From: Nicola Spencer on behalf of Planning
Sent: 02 February 2018 11:35
To: Planning Scanning
Subject: FW: Ref 9 park drive Rustington

R/243/17/Hh Please upload and redact as withdrawn email

On 22 Jan 2018, at 12:38, Mark Jones  wrote:

Proposed North elevation

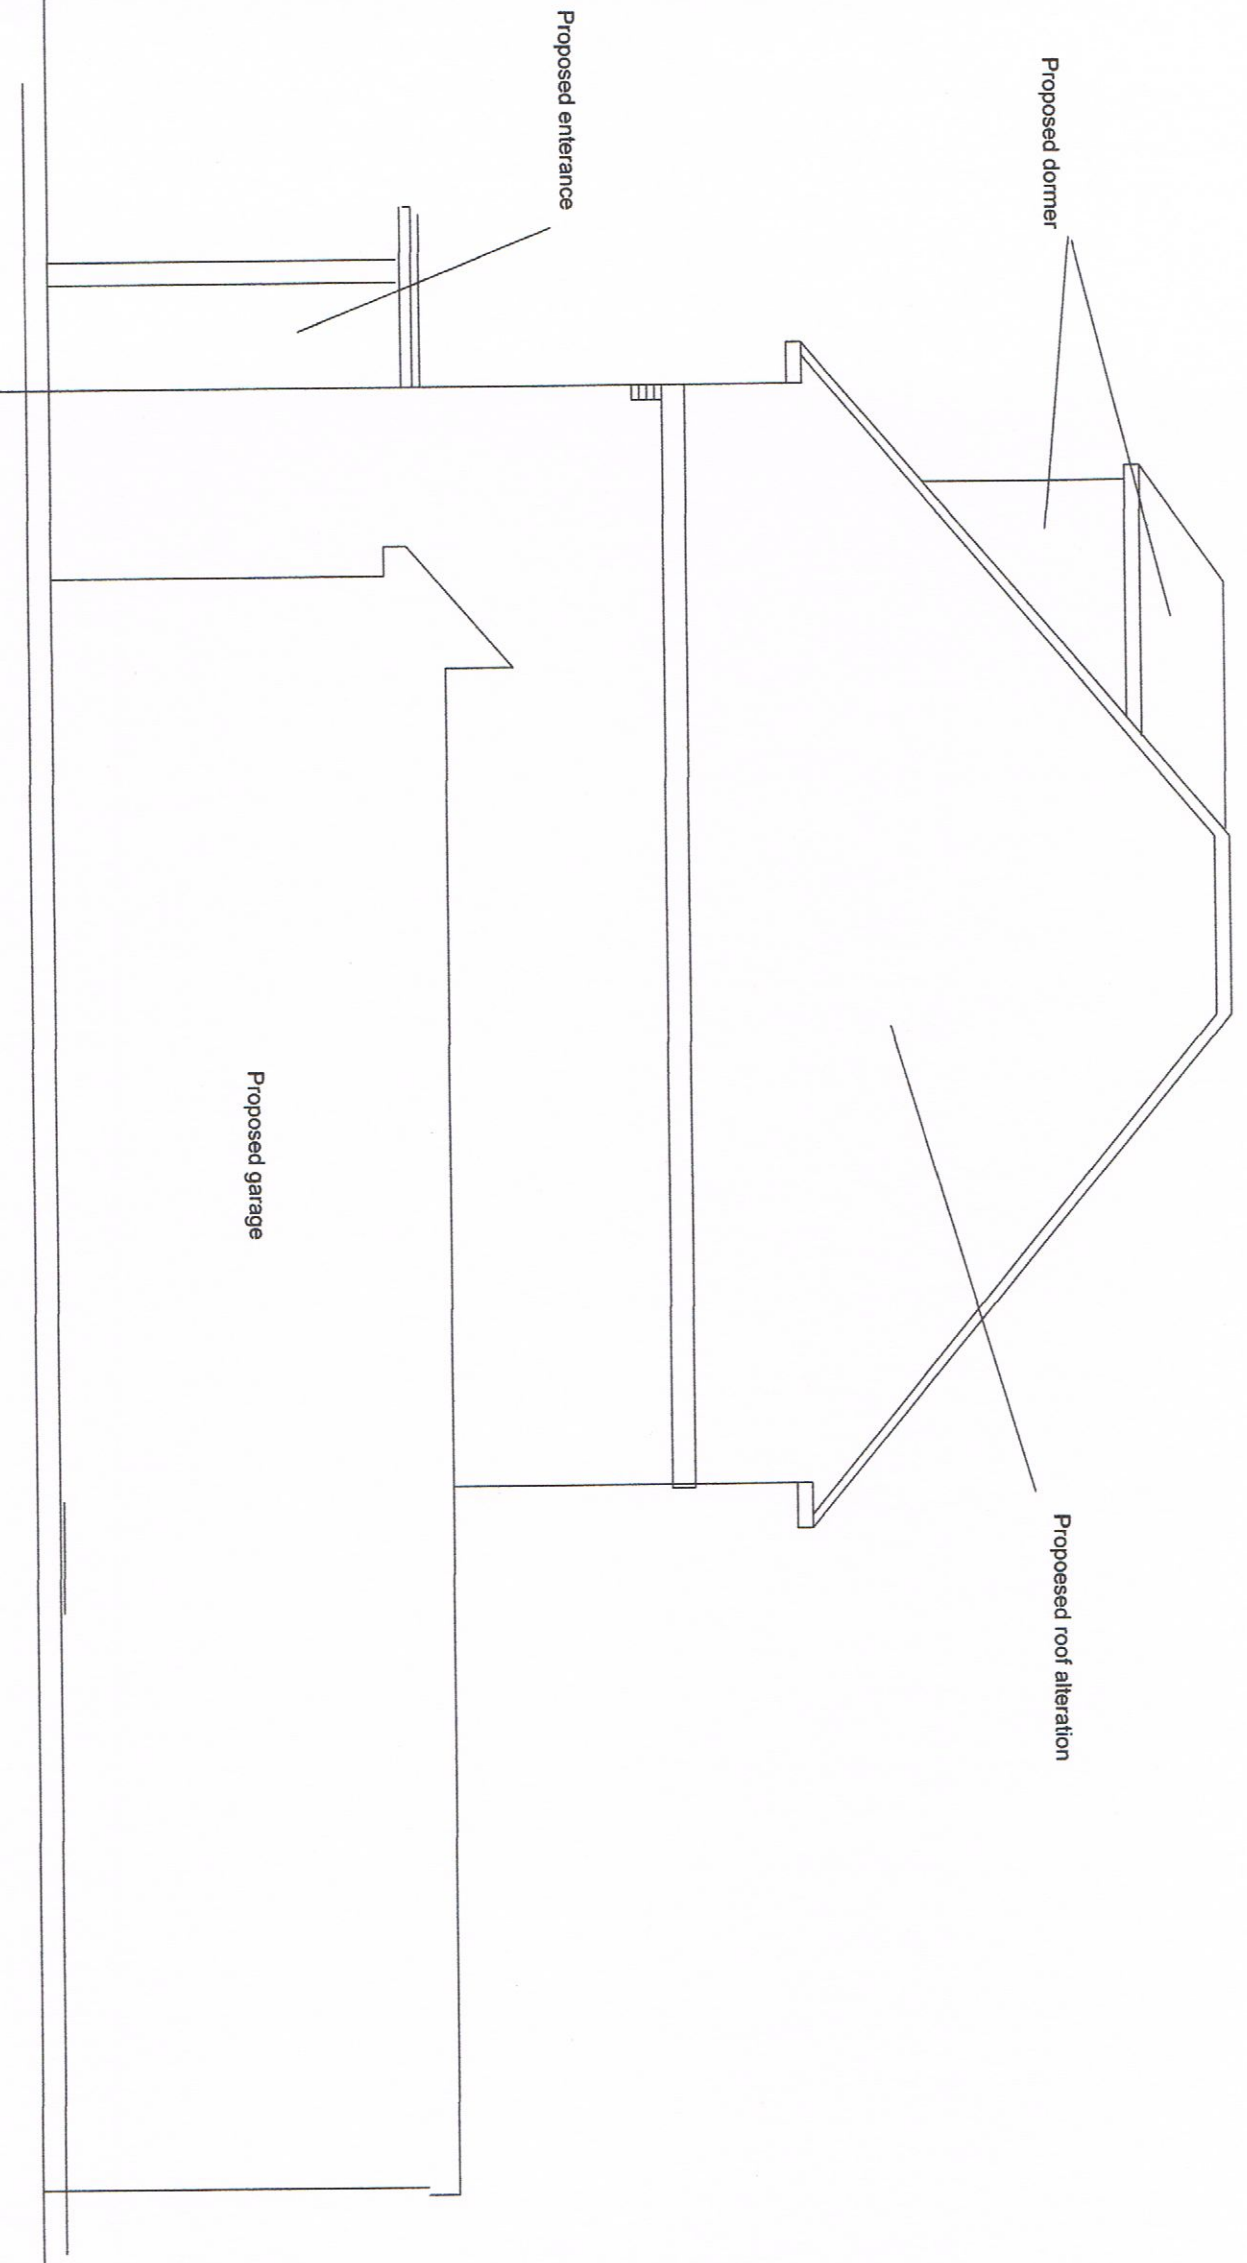
2. The rear roof terrace would lead to a loss of privacy to adjoining occupiers at No.11 due to increased overlooking of the garden and rear windows of this property. I note that a screen is proposed albeit this is not shown on the proposed north elevation. In addition, given the depth of the rear roof terrace I also feel there is an adverse impact upon the properties to the rear, No.5 and No.6 Herne Lane . Whilst privacy screens up to 1.8m could be introduced to address this matter. I have concerns that in the proposed position and given the height this would increase the bulk of the building and also lead to the this part of the extension being unduly dominant on the neighbouring properties. I also have some reservations on the potential impact from the large rear rooflights. As such is contrary to policies Dev19 and Gen7

Proposed roof plan Plan
Scale 1:50 Paper Size A3

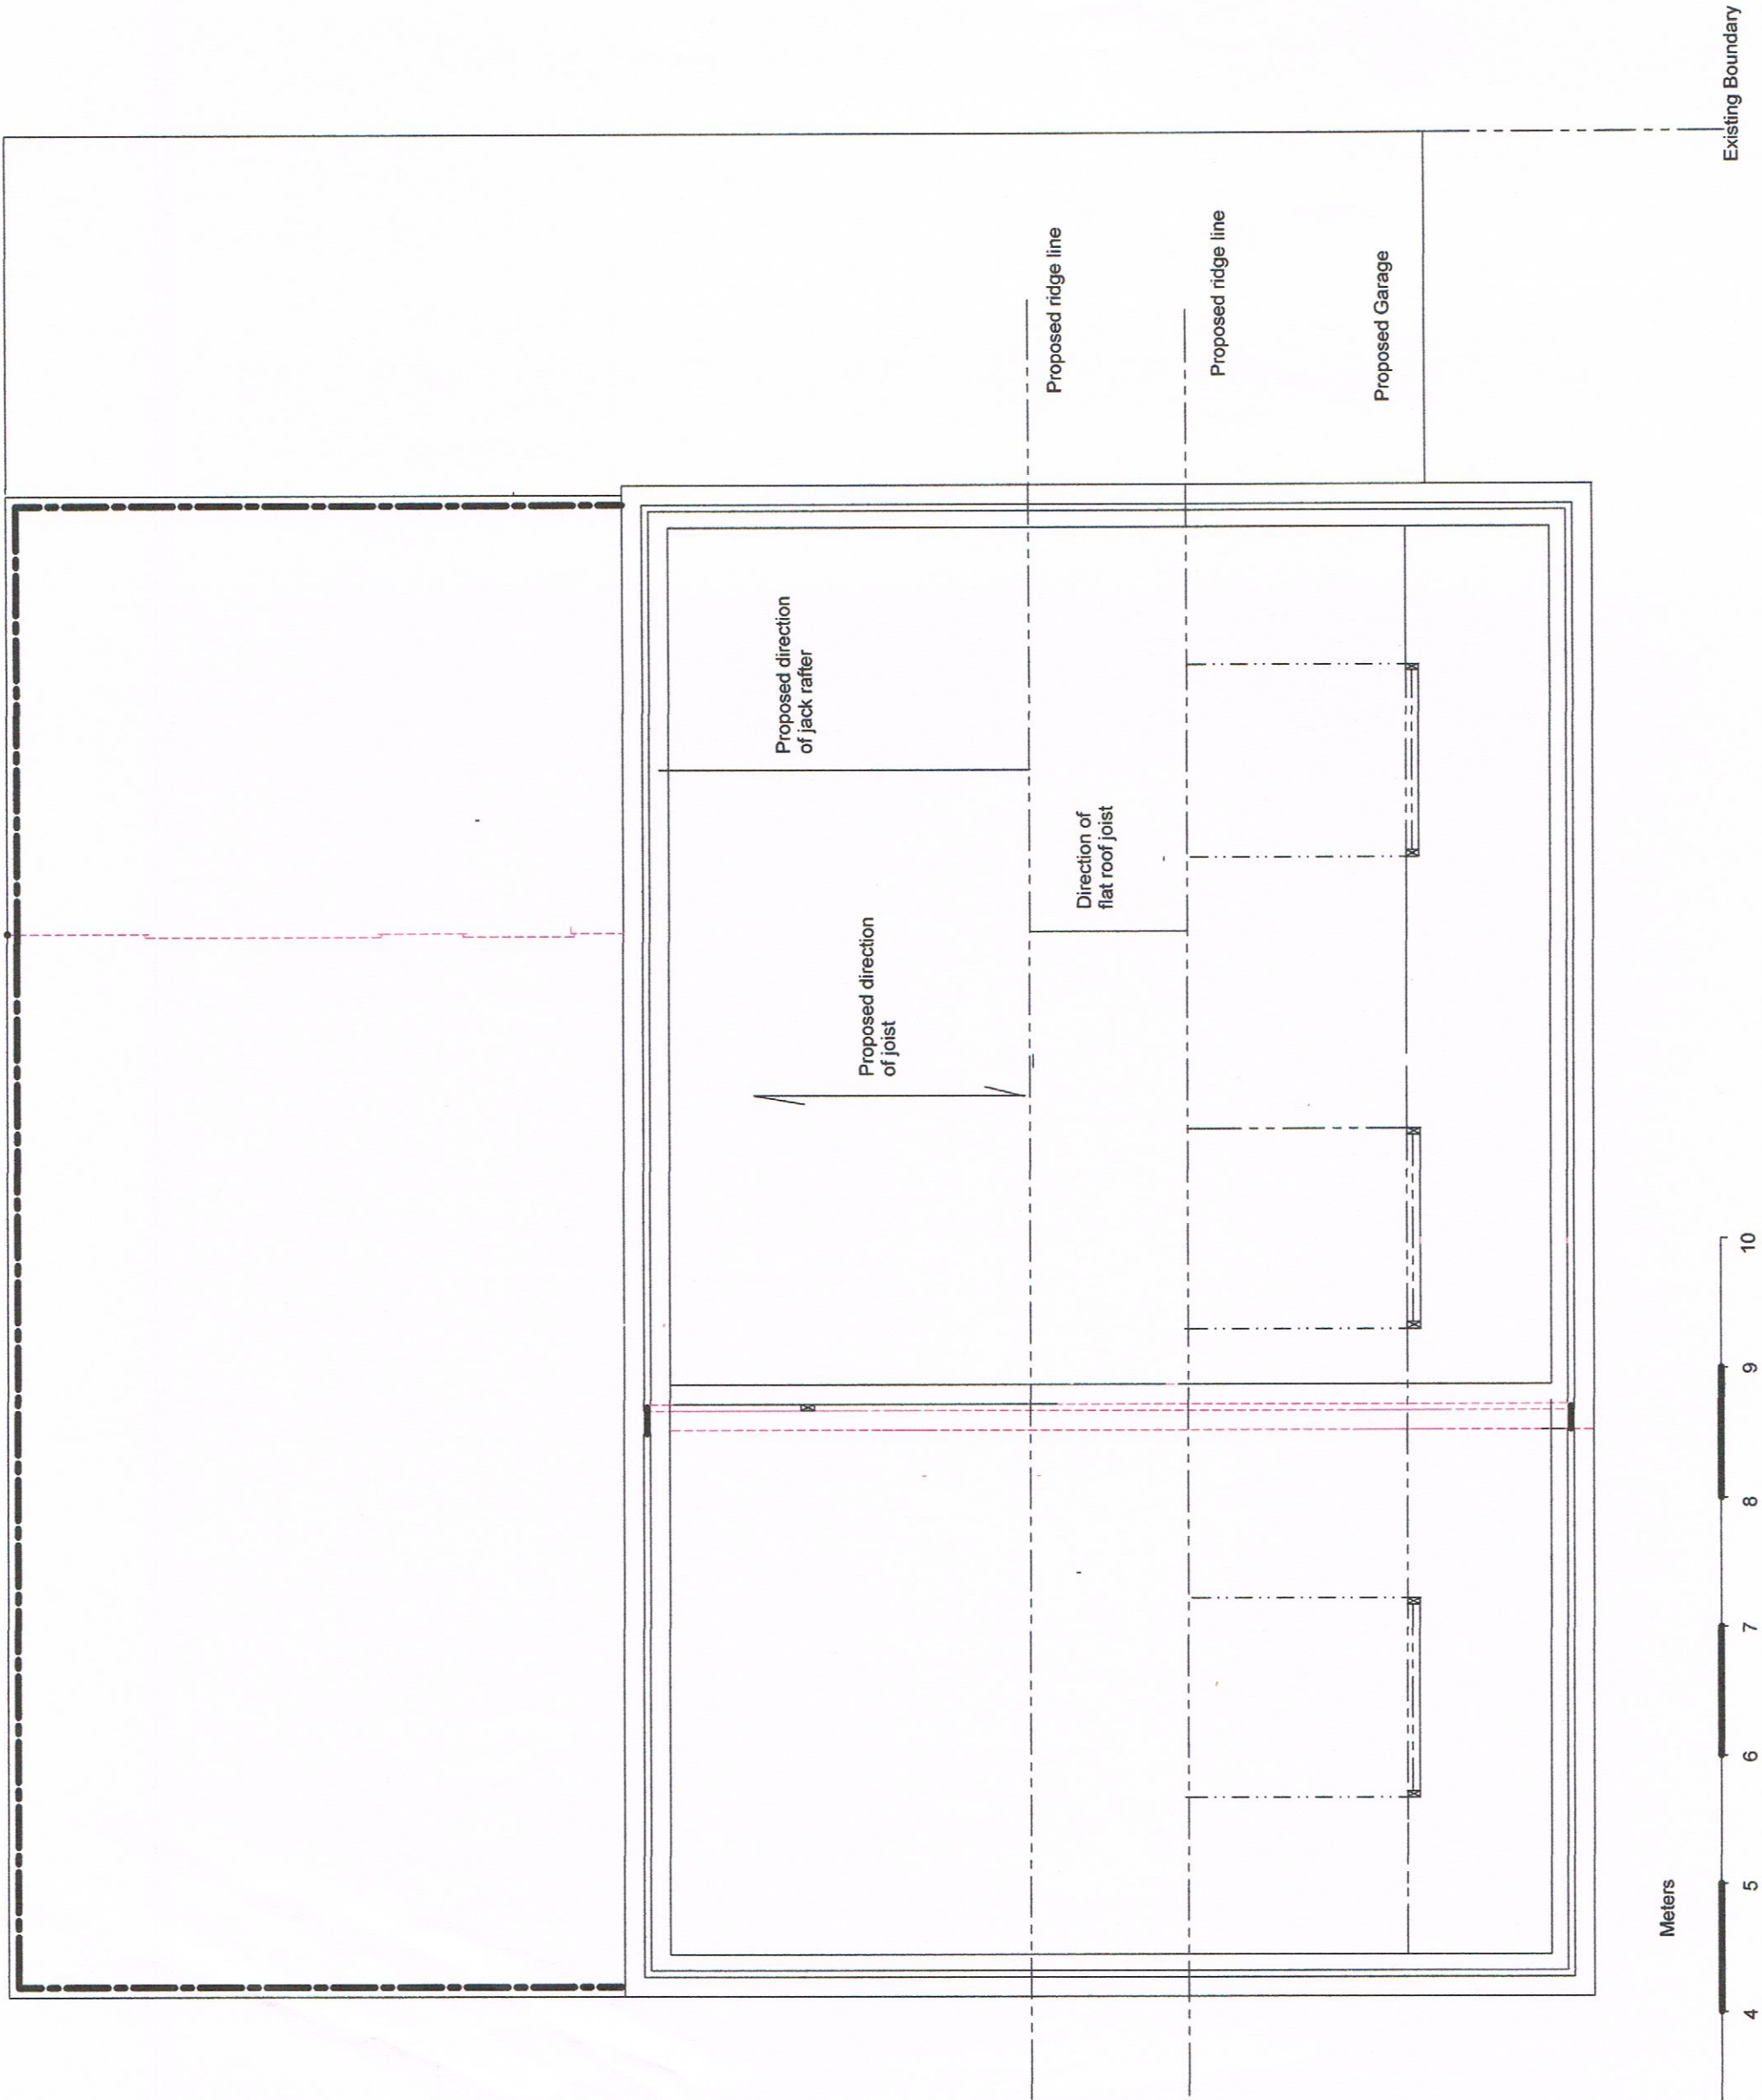
1. The proposed extensions involving the loss of the conservatory and a two storey side extension together with a change to roof including an increase in height of the property significantly changes the appearance of the property,. However, whilst change alone is not harmful I think in this case the proposed changes are not subordinate to the main property. Policy Dev19 (ii) and (ii) requires (ii) the extension sympathetically relates to and is visually integrated with, the existing building in siting, design, form, scale and materials;
(ii) the extension is visually subservient to the main building;
Unfortunately I think the proposal does not meet these requirements. I think the overall increase in height and bulk of the building which is further enhanced with the proposed dormer windows would appear unduly dominant against No.11 and also to the flats south the south. Furthermore, whilst there are slightly higher properties to the north of No.11 it is considered that proposed development will be unduly dominant and harmful to the character of the wider area.
